Re: Objection to Amended Planning Application: R/64/17/PL

Location: St Mary's Close, Hurst Road, Rustington, BN16 3AP

We are responding to the amended plans for this development by MJH Homes. In our view this new proposal changes very little & most of our original comments in our letter dated 12th May remain valid.

Drg No: 151117_SS-01 Rev: D

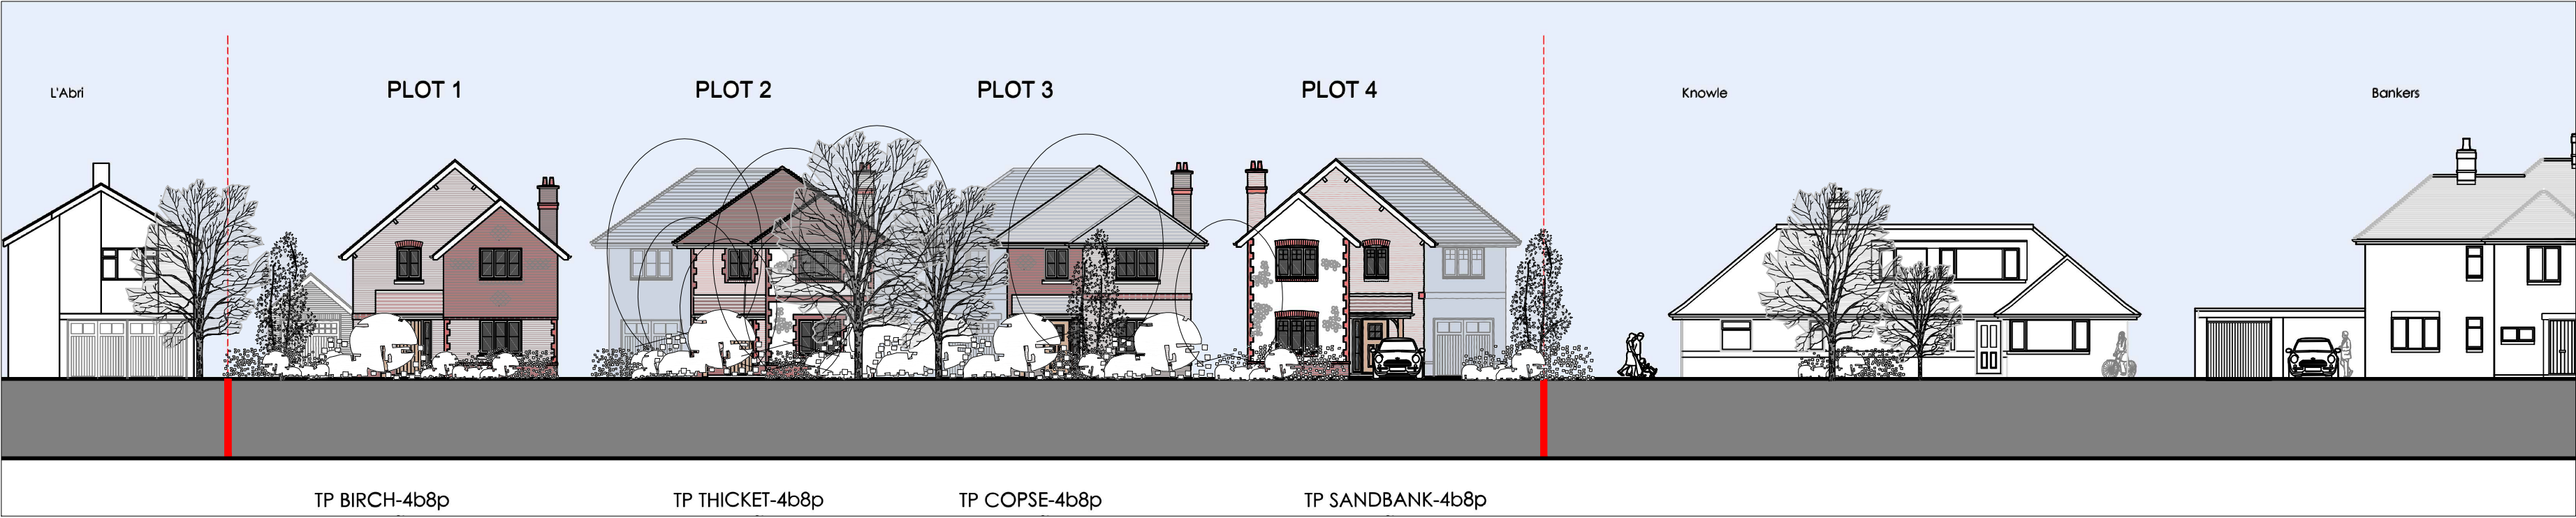
- 3) **Design & visual impact** -- The proposals are for two slightly different designs and the developer has attempted to make them look different by using various cladding materials. Further detail has been provided in the amendment, however our objection remains - that as seen from the elevation plans this is just superficial, they still look very similar (MJH Substitute Street Scene Drawing). They do not fit with the individual properties in Hurst Road and the proposed development will spoil its appearance and character. In fact the proposed scheme contravenes the Local Plan - D SP1 Design as it does *not* "Respect, improve and enhance the existing surrounding environment".
